# CITY OF ALBUQUERQUE

February 11, 2022

**Re: Caterpillar Clubhouse**  
**803 2<sup>nd</sup> Street SW**  
**Traffic Circulation Layout**  
Architect's Stamp 02-02-2022 (K14-D227)

Based upon the information provided in your submittal received 02-09-2022, the above referenced plan cannot be approved for Building Permit until the following comments are addressed:

A3 ENLARGED RAMP DETAIL
SCALE: 1" = 8'-0"

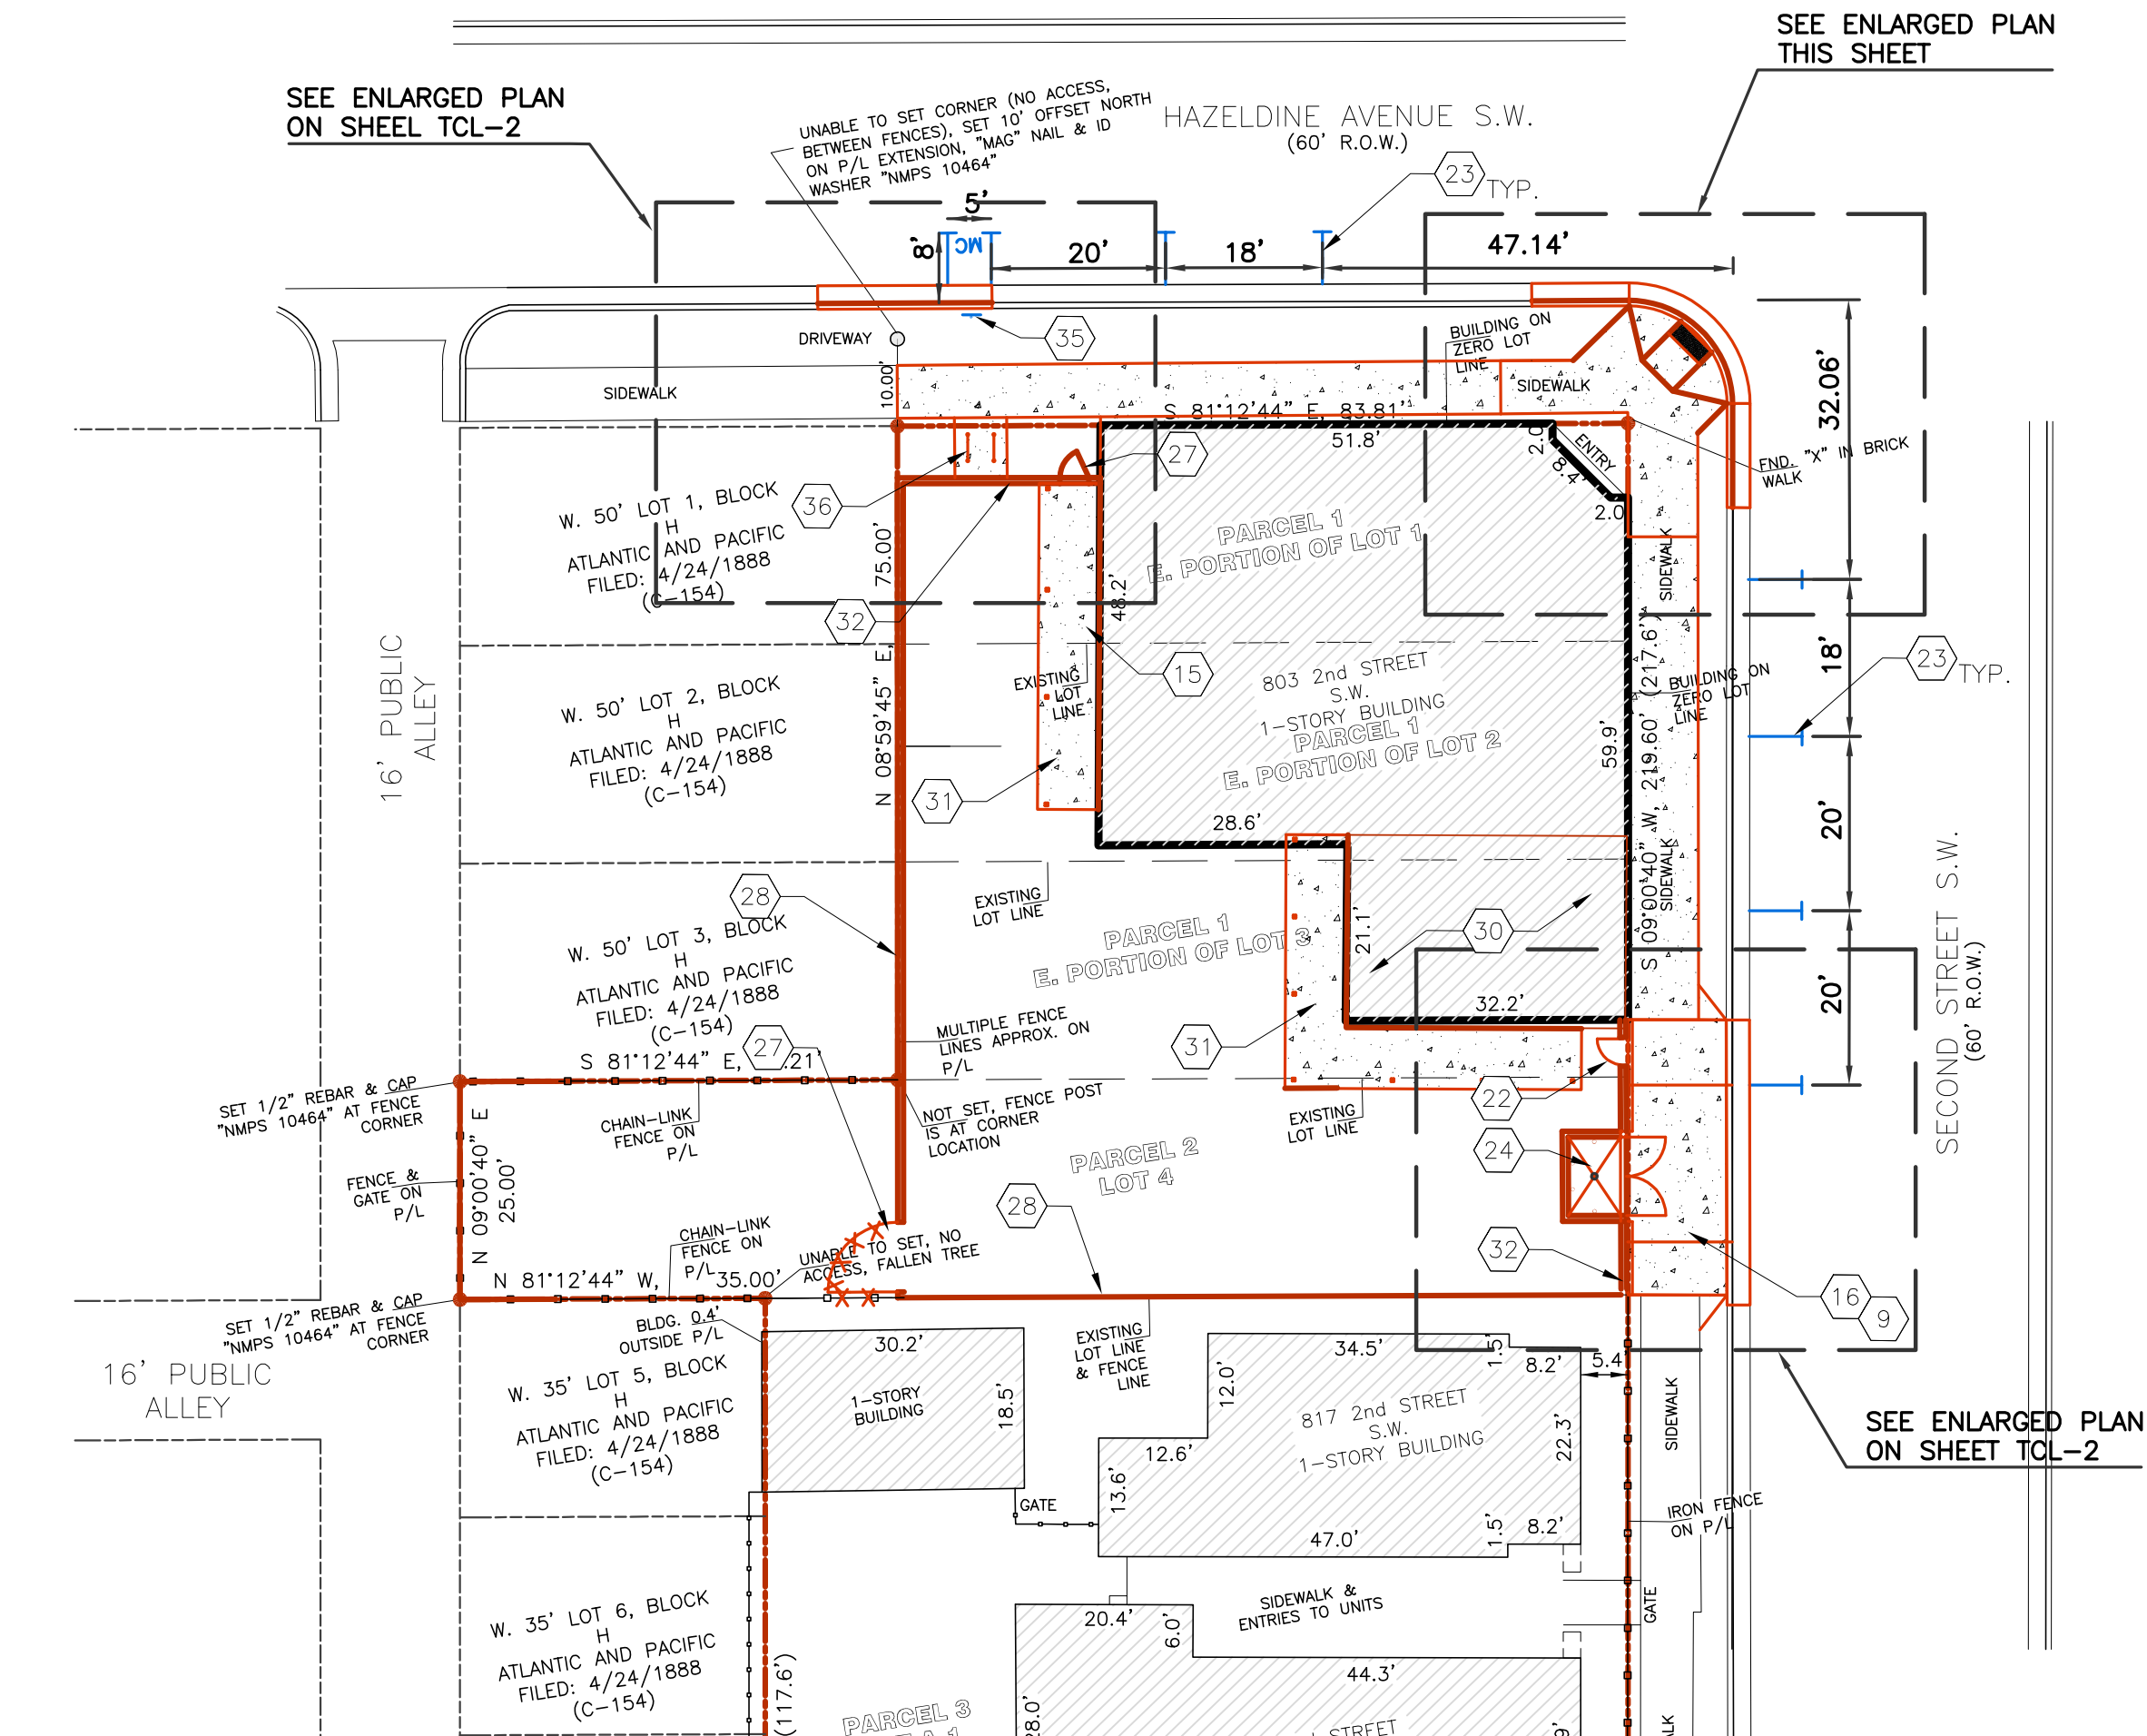
- Detail for proposed driveway will need to be provided.
  - Ramp at corner of Hazeldine/2<sup>nd</sup> St:
    1. Ramp design will need to be MODIFI~~ED~~ because handrailing will not be allowed within COA ROW.

A1 TRAFFIC CIRCULATION LAYOUT
SCALE: 1" = 20'-0"

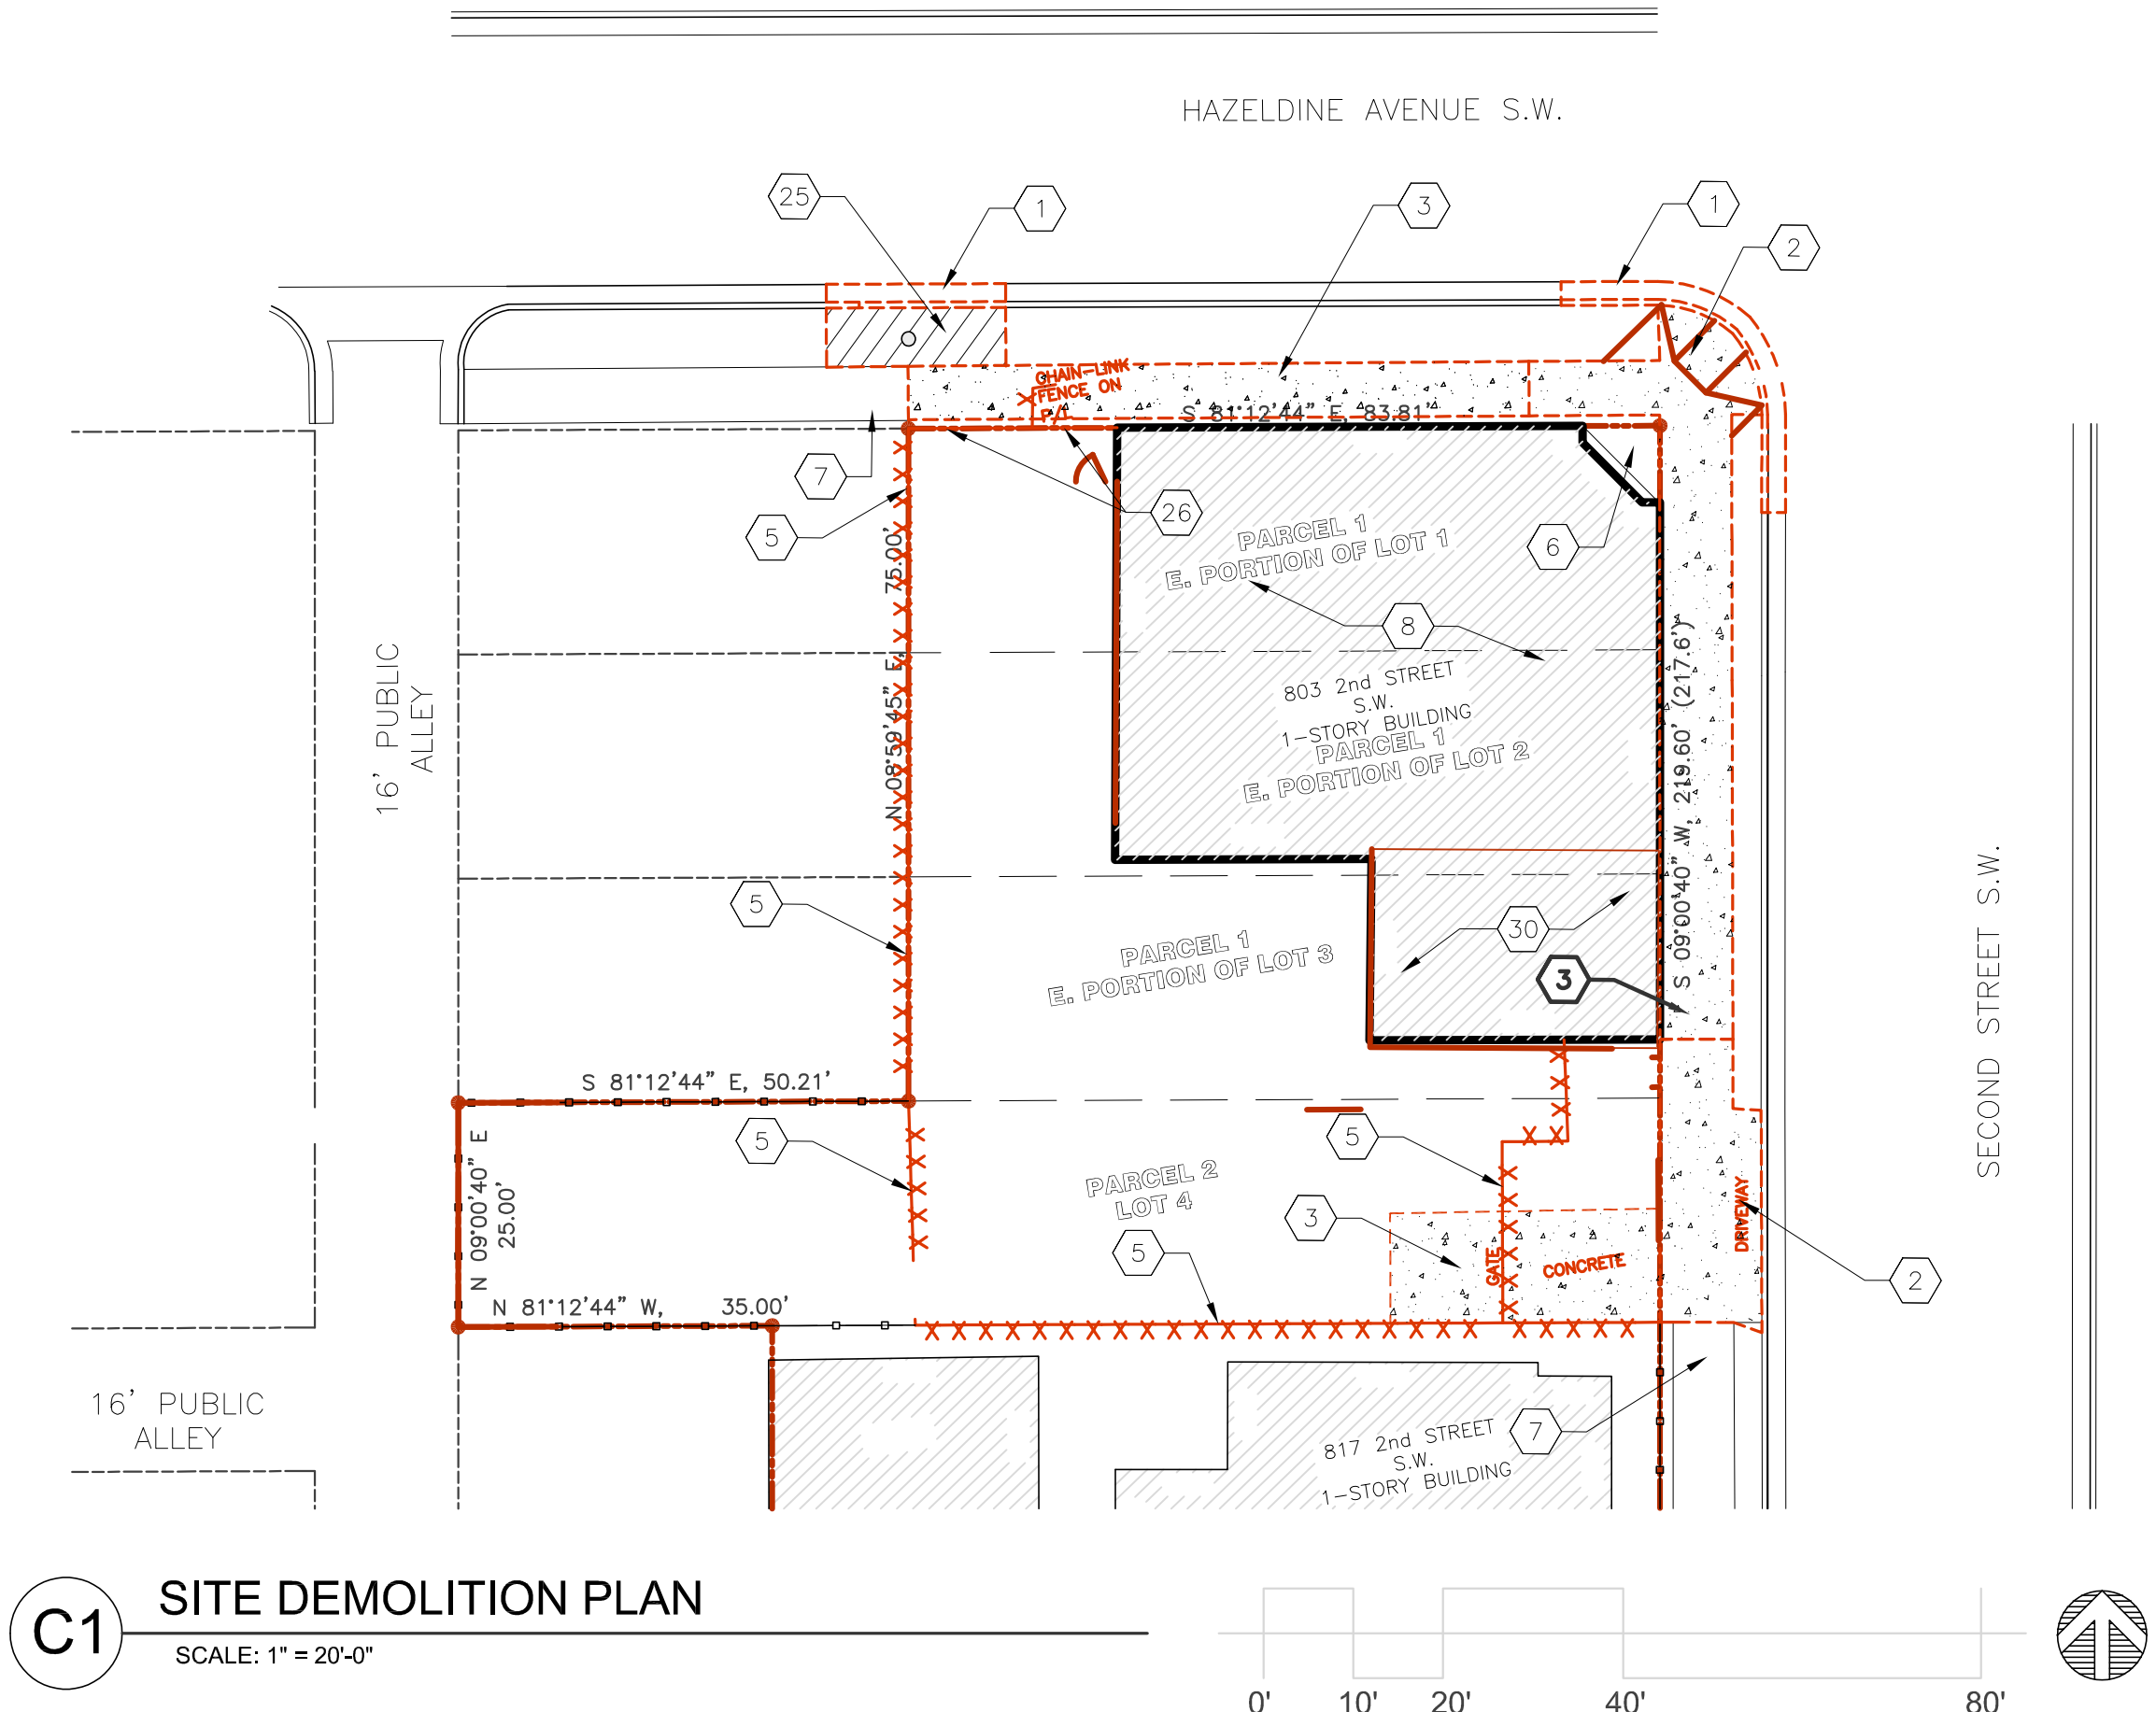
**Coordinate/discuss with Zoning.**
3. **Hazeldine Ave/2<sup>nd</sup> St. Frontage:**
  - Proposed driveway needs to be locate on proposed development frontage on Hazeldine and width on detail C1/TCL-s will need to be provide and reference COA std dwg for overall detail of proposed drivepad.

- On street parking dimensions needs to follow **IDO and DPM design requirements** for 2<sup>nd</sup> St and Hazeldine.
  - Limits of new versus old sidewalk will need to be identify on site plan..

- The ADA parking stall (2<sup>nd</sup> ST):
    1. Will need to follow IDO and DPM design requirements. This stall is in conflict with driveway and proposed ramp and std curb and gutter. This is a safety conflict.

2. Conflict between COA std dwg 2443 and 2425 A&B which one is being referenced for this infrastructure. Please pick one. SEE DPM.
  3. A header curb is being proposed at building entrance. This is consider an obstruction for ADA pathway.

4. You will need a taper between proposed sidewalk and drivepad/ramp joint.
- 
4. The ADA accessible spaces must include an access aisle. Van accessible aisles should be 8ft wide; all others should be 5ft wide.

11. Per the DPM, a 6 ft. wide ADA accessible pedestrian pathway is required from the public sidewalk to the building entrances. Please clearly show this pathway and provide details (**If applicable**).

12. Per DPM, a 6 ft. wide ADA accessible pedestrian pathway is required from the ADA parking stall access aisles to the building entrances. Please clearly show this pathway and provide details.
